From: Richard Atkinson [REDACTED]
Sent: 17 May 2019 11:29
To: Stuart Corbey
Cc: Rob Lowe
Subject: Re: AL/30/19/HH Stable Cottage Norton Lane -

From: Stuart Corbey <Stuart.Corbey@arun.gov.uk>
Date: Thursday, 16 May 2019 at 14:32
[REDACTED]
Subject: AL/30/19/HH Stable Cottage Norton Lane -

Drawing Number: 2018/20/04 Rev.

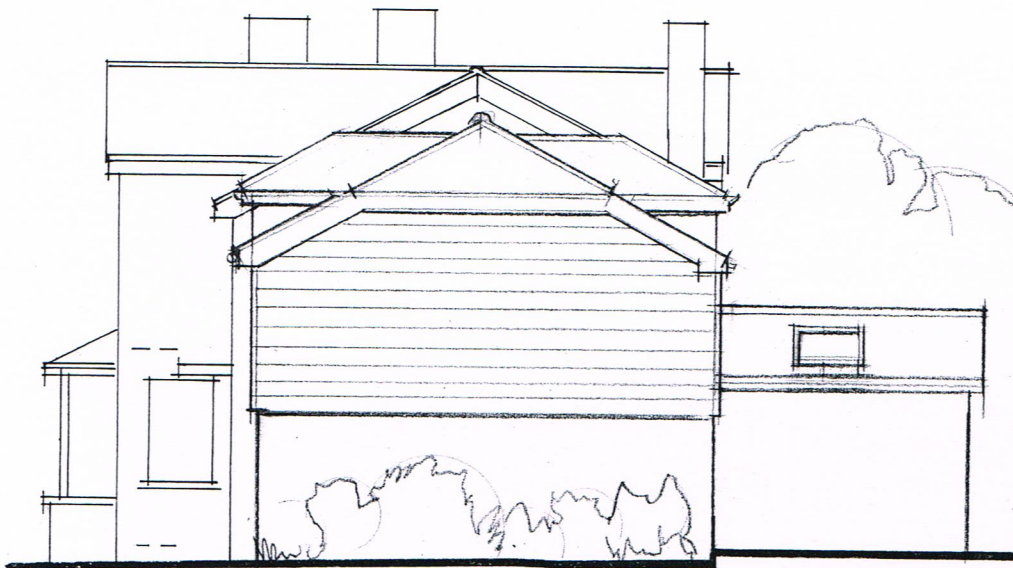
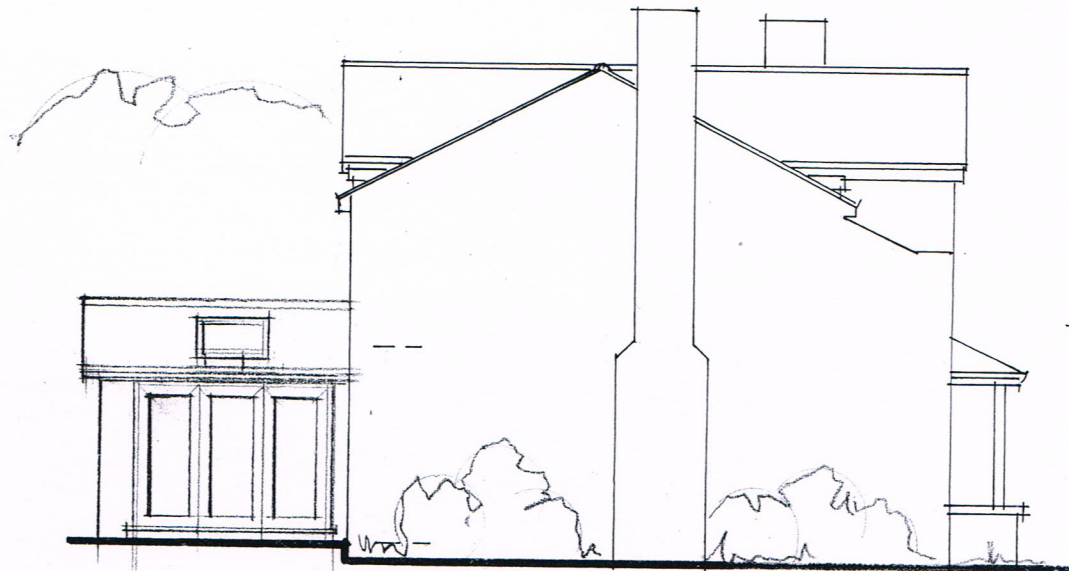
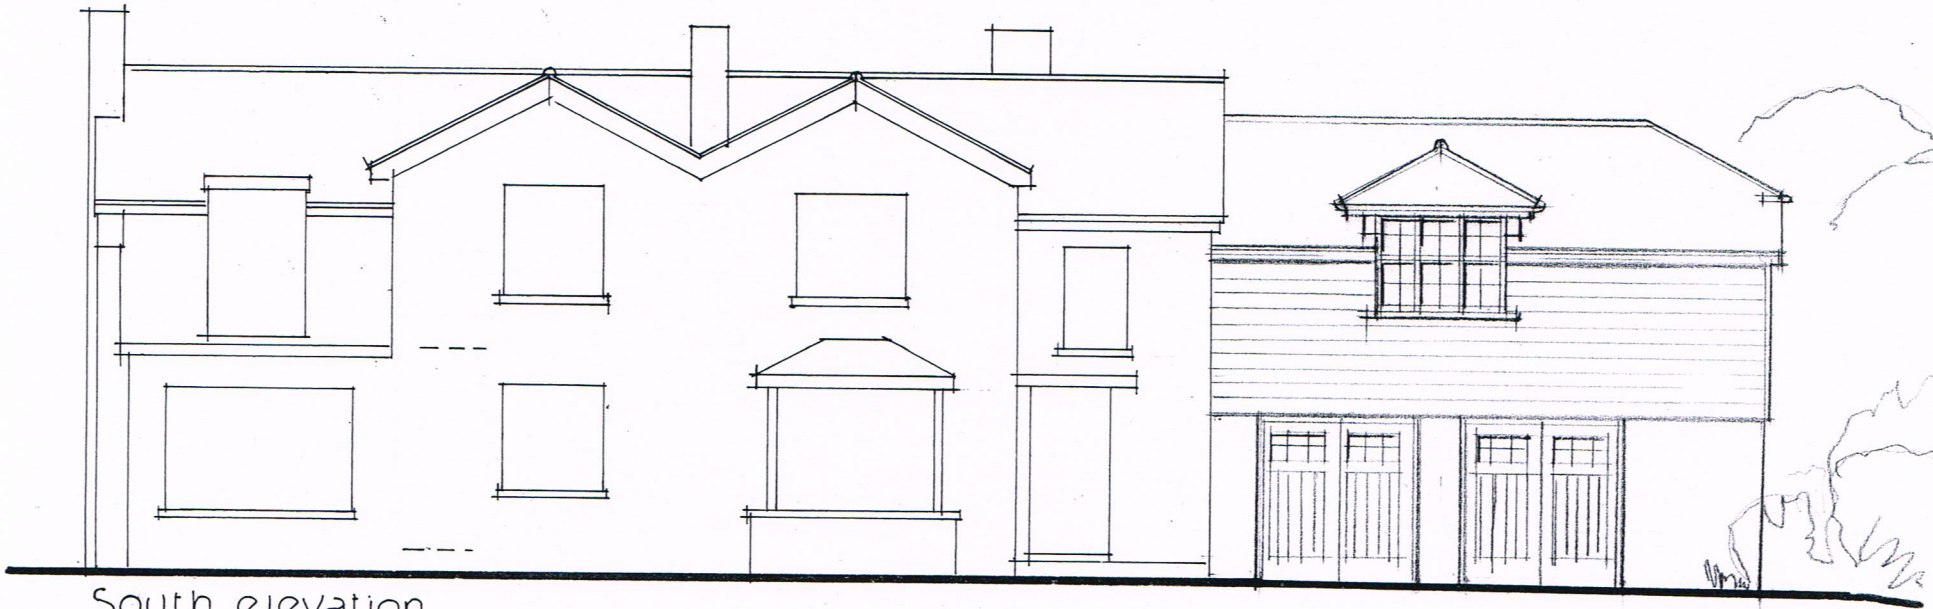
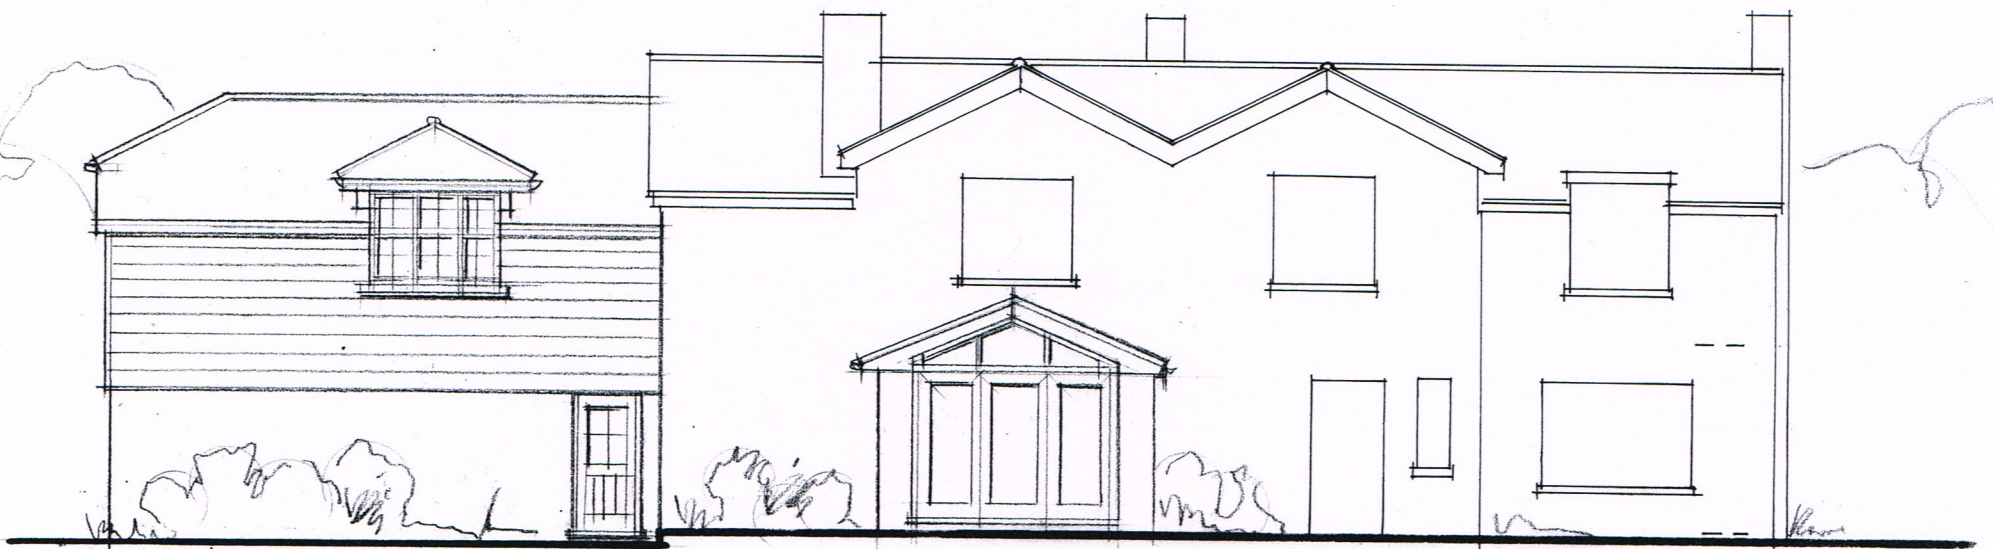
I have just had word from our conservation team that the design would need to be tweaked in order for it to respond more sympathetically to the conservation area and appearance of the existing dwelling. To alter the barn hip to a gable would be preferred. We consider this would make for an acceptable scheme and support the Policies on design within the Arun Local Plan and Neighbourhood Policy requirements respectively.

1. Please substitute the attached revised drawings 4A & 5A showing the design amended with the gable end.
2. Agreement to the extension of time to 31/05/2019.
